PROPERTY AT 20 AVON ROAD, PYMBLE

PYMBLE LADIES COLLEGE – GREY HOUSE PRECINCT SSD-17424905

State Significant Development SSD-17424905
 Pymble Ladies College – Grey House Precinct
 20 Avon Road, Pymble (Lot 1 DP 69541)

Table 1 RESPONSE TO INFORMATION REQUEST

## ELC UNENCUMBERED AREA

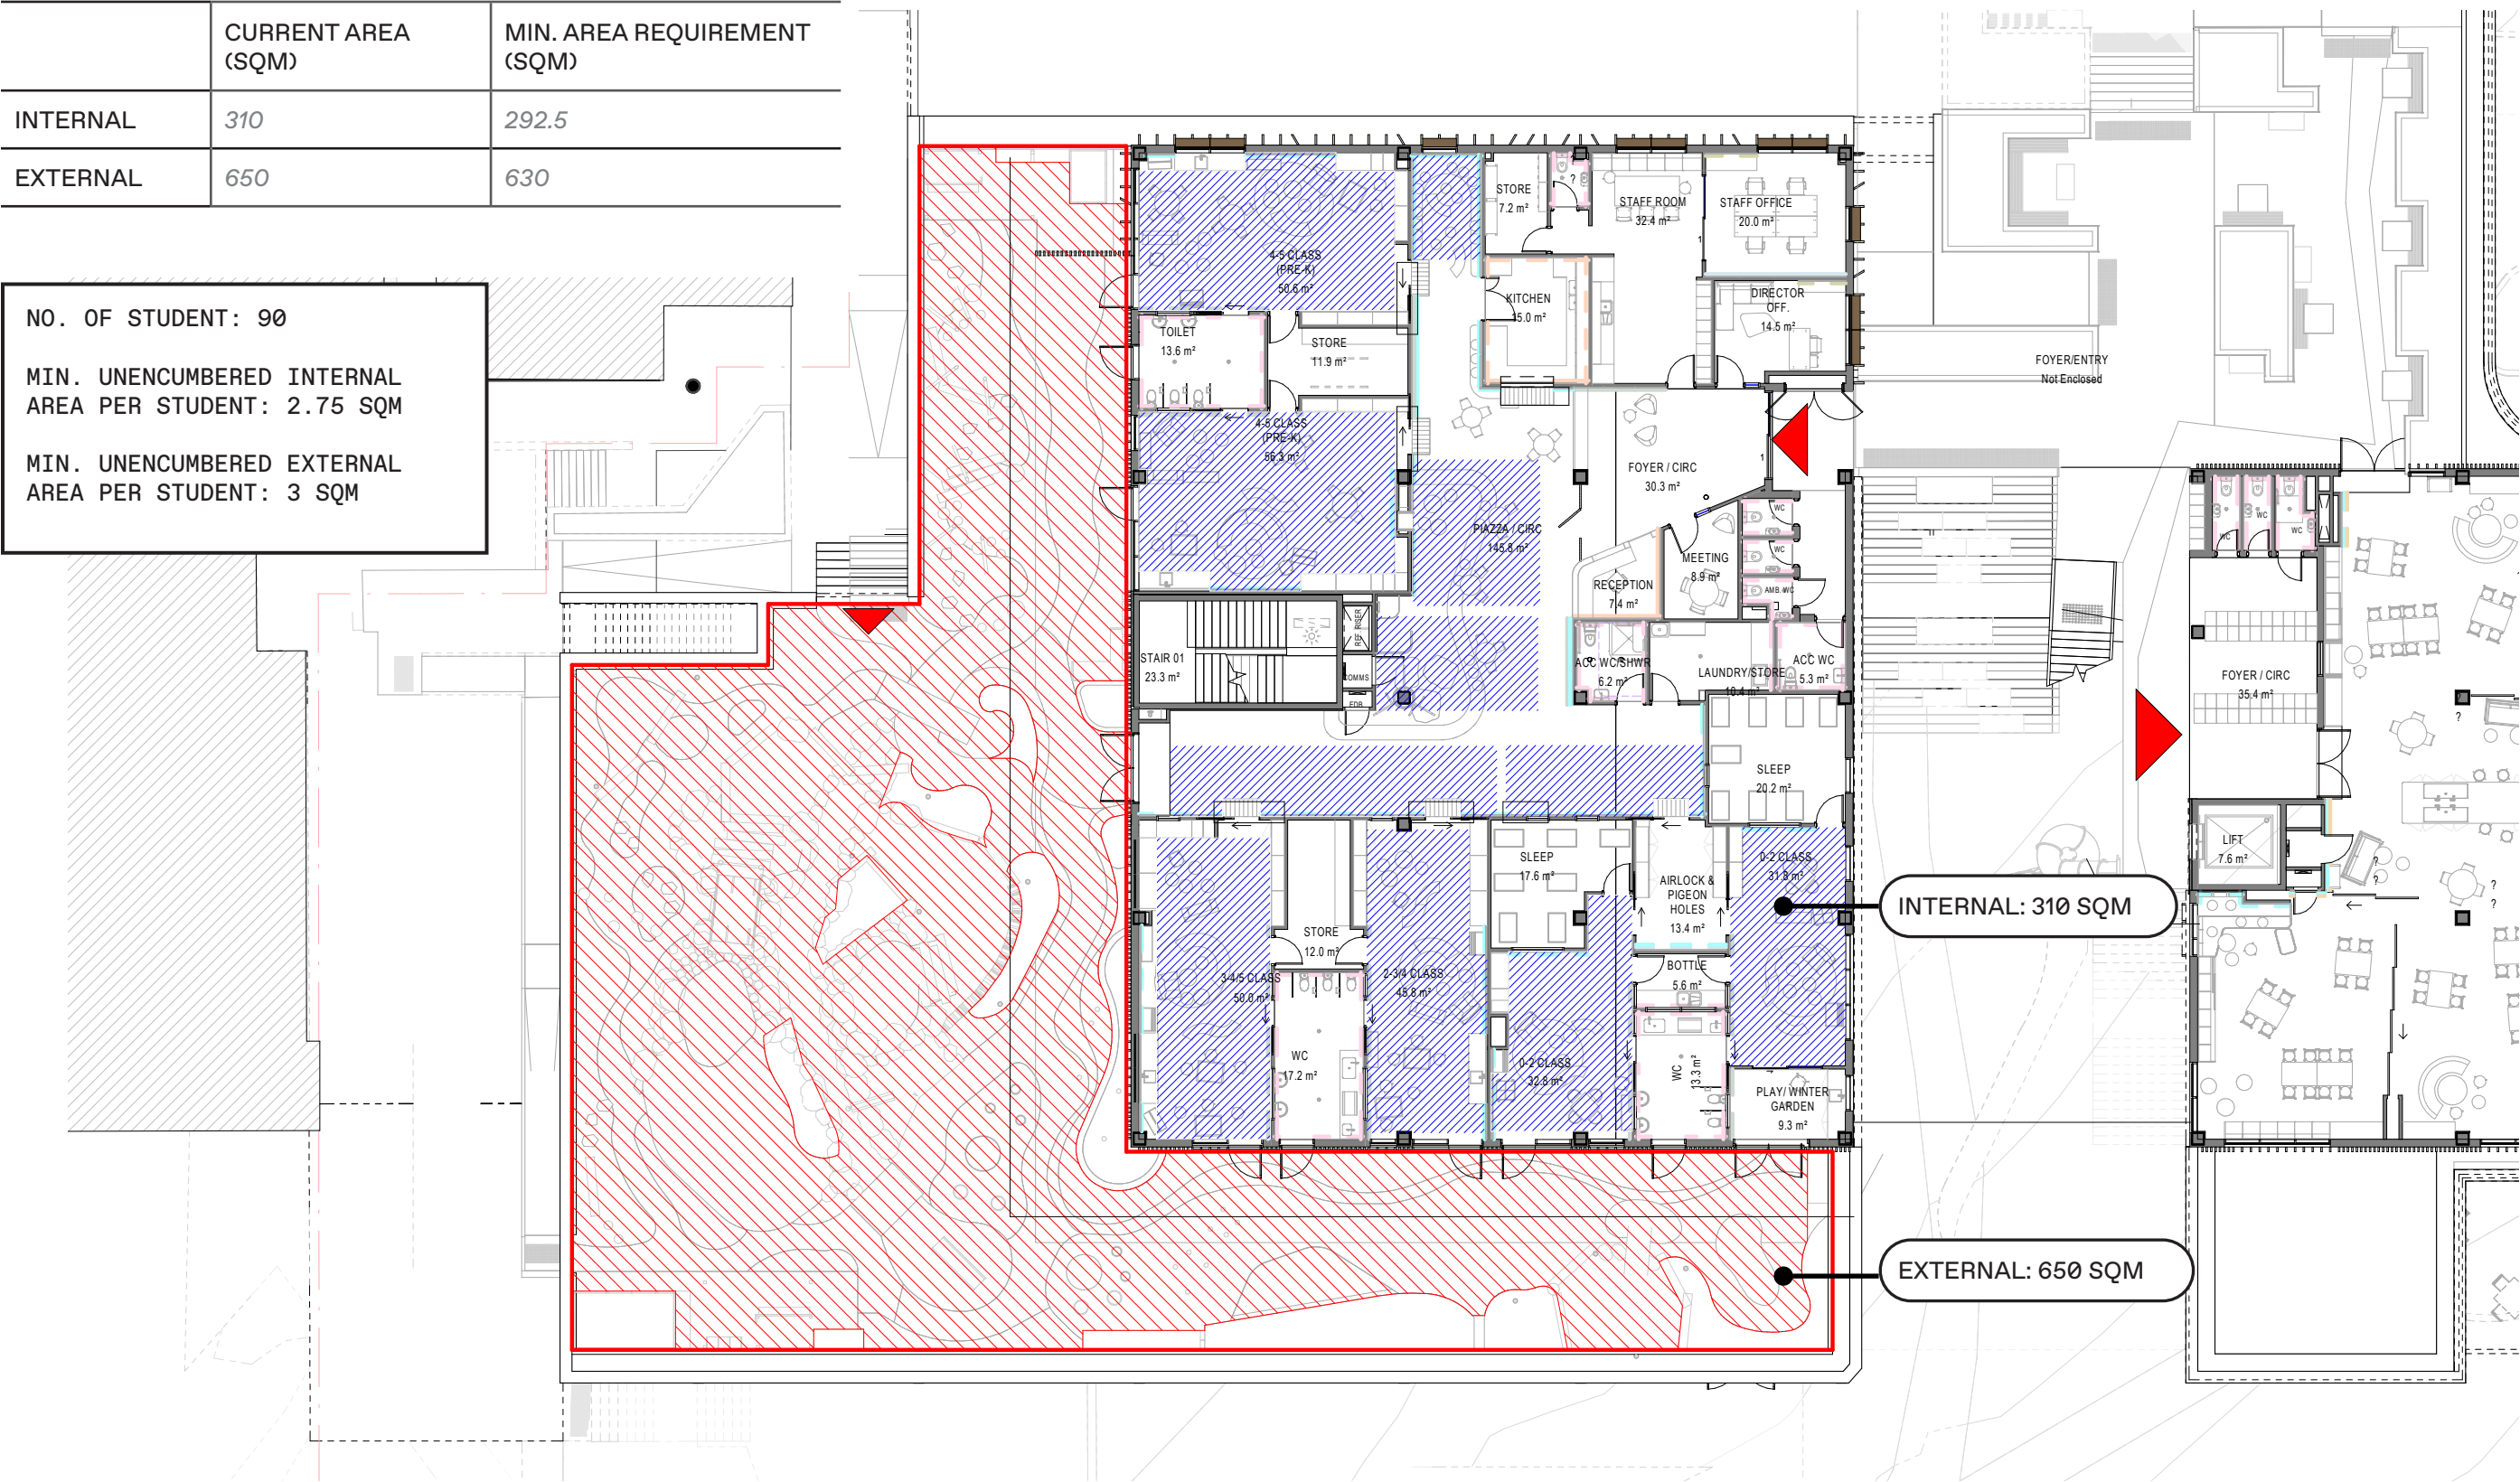
<p>child care assessment table submitted with the EIS does not include any numerical data regarding the unencumbered outdoor and indoor play areas to demonstrate their compliance with the relevant standards (the childcare assessment table include incomplete highlighted information rather than a number). The Department has previously requested this; however the information has not been submitted.</p> <p>The Department requires you to clearly demonstrate on the architectural plans and in a table, the delineation of the unencumbered outdoor and indoor play area for the proposed ELC, to comply with the requirements of the Education SEPP.</p>	<p>The internal and external unencumbered areas are 310 sqm and 650 sqm respectively which is above the minimum requirement of 292.5 sqm and 630 sqm for 90 students. The internal and external spaces are clearly demonstrated within the Design Report addendum, page 2 (Appendix 3).</p> <p>The unencumbered space provides more than the minimum area required which includes areas of low density planting functioning as 'bush track' play experiences allowing the children to immerse themselves and interact with the planting. The design has minimised the de-linestation of specific pathways, instead of providing differing paving treatments as part of the discovery and self-led play strategy. The unencumbered area does not include areas for; storage, paths, raised planter beds or screen planting.</p>

## Area Schedule

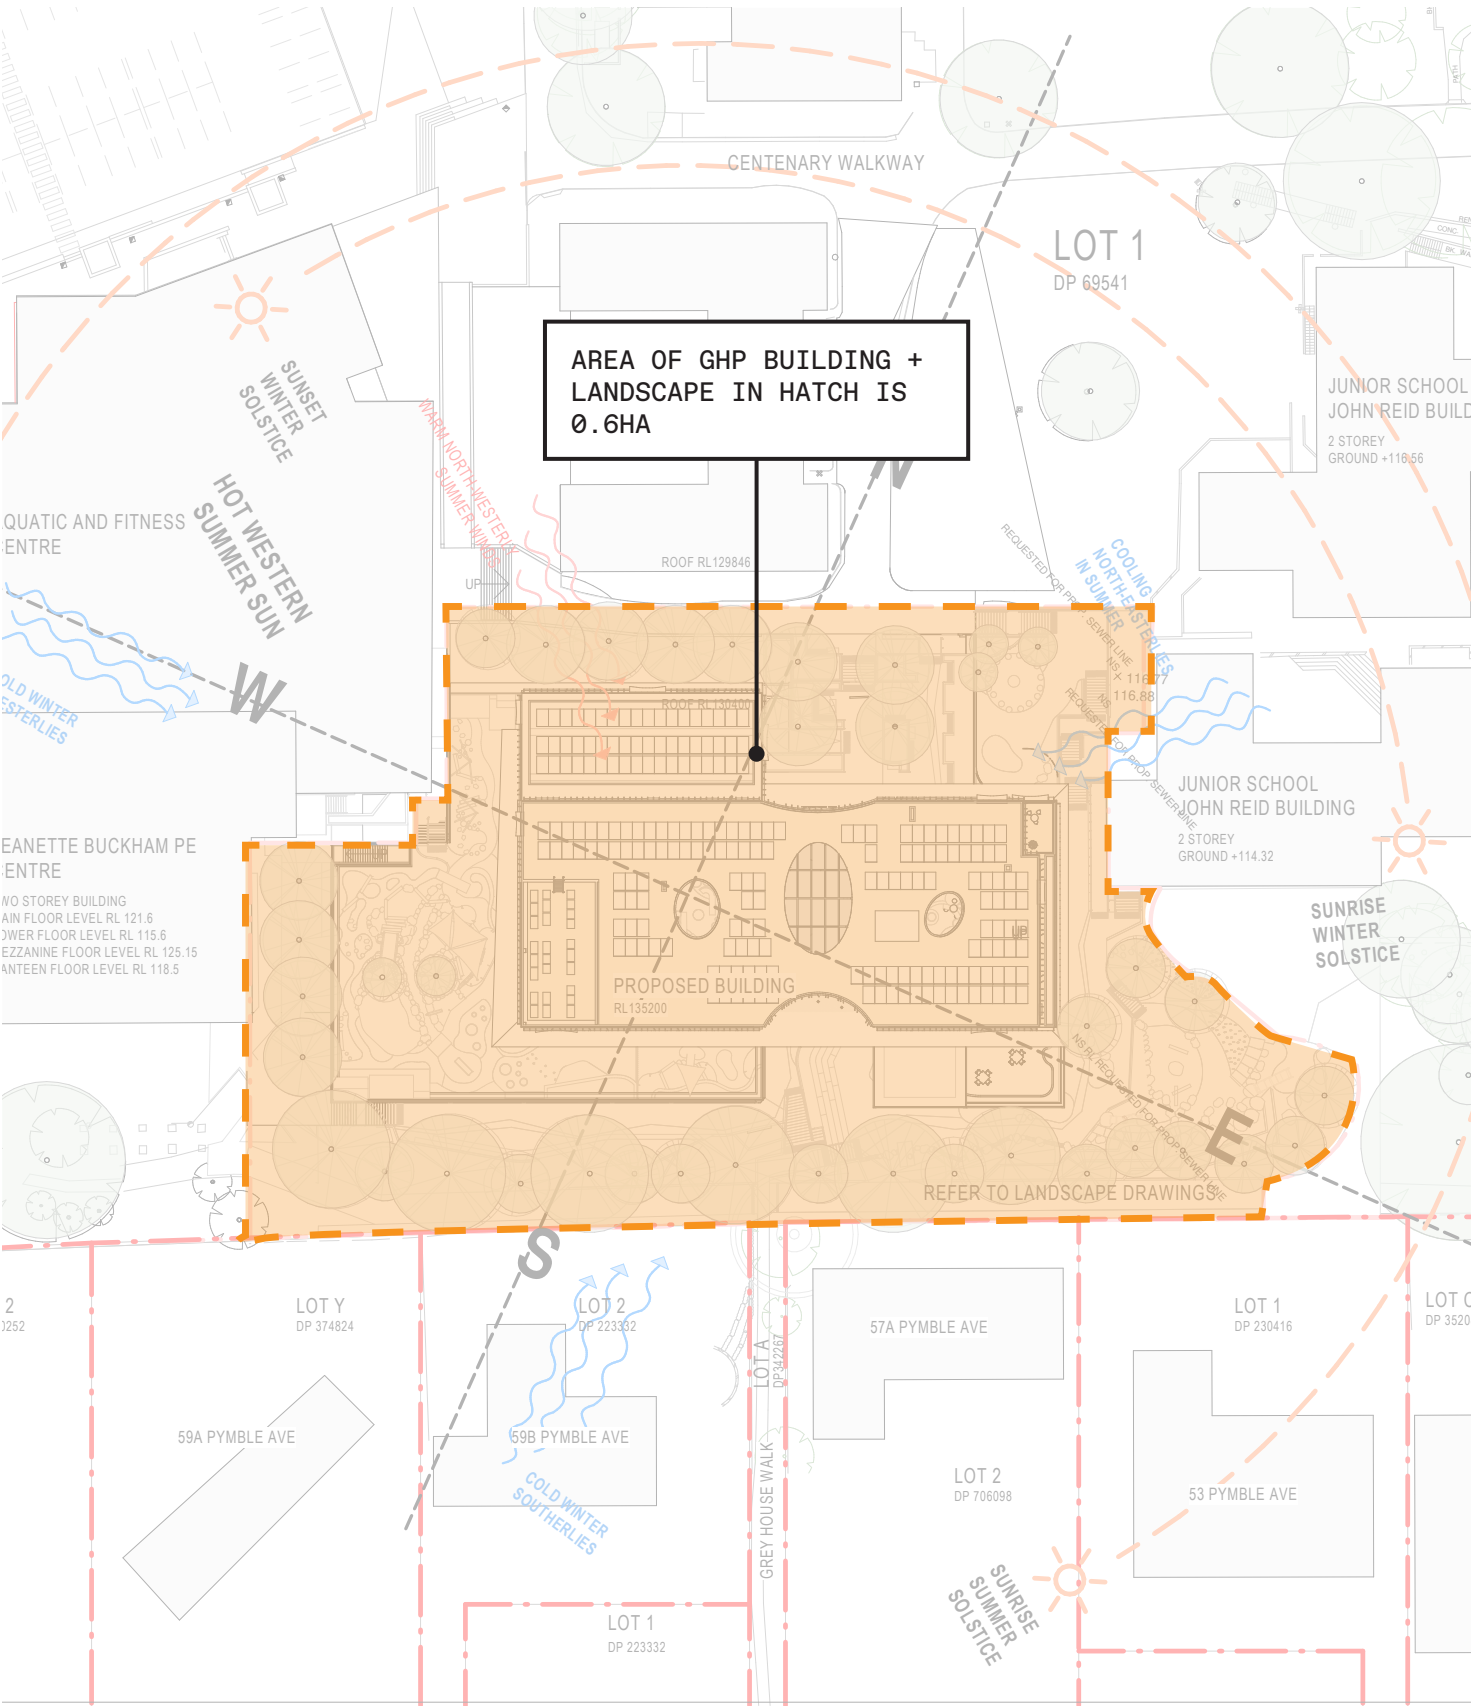
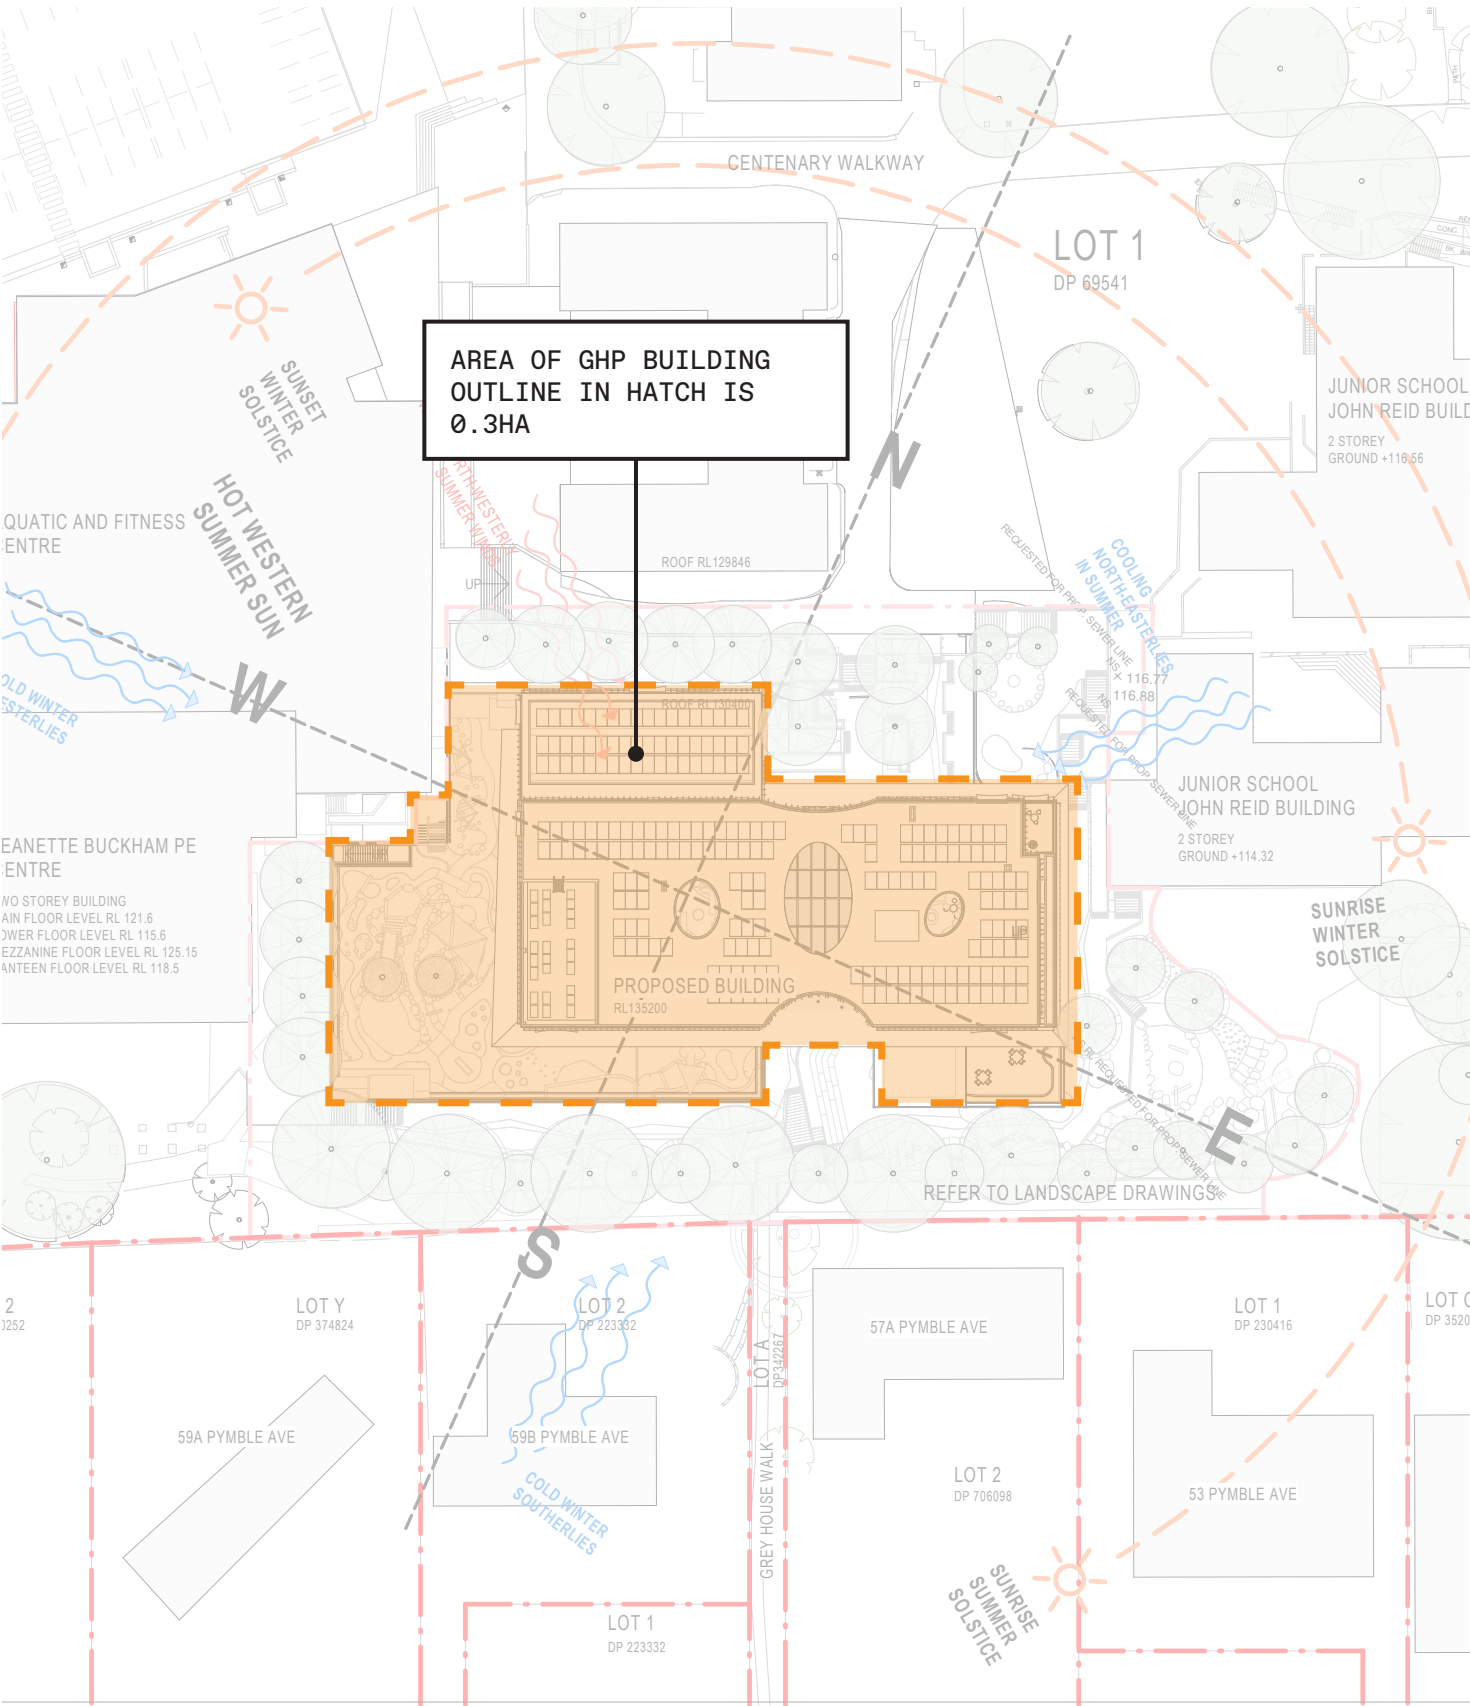
<p>3. The architectural drawings and supporting documents in the RtS, demonstrate that the northern portion of the building footprint has been reduced. This implies a change in the overall gross floor area (GFA) of the development. Please provide an amended schedule of the GFA to indicate the extent of its reduction.</p>	<p>A revised floor area schedule has been provided within the Design Report Addendum at page 3 (Appendix 3). The revised total internal area is 5,837m², however it is noted that this is not the gross floor area (GFA), but the total internal area. As there is no GFA restriction across the site, it is considered this is suitable.</p>
<p>4. Please confirm whether the site area for the Grey House Precinct is 0.3ha or 0.06ha.</p>	<p>The total area of the GHP building is 0.3ha, with the overall GHP site area including landscaping elements being 0.6ha, this is referenced within the Design Report Addendum on page 4 (Appendix 3).</p>
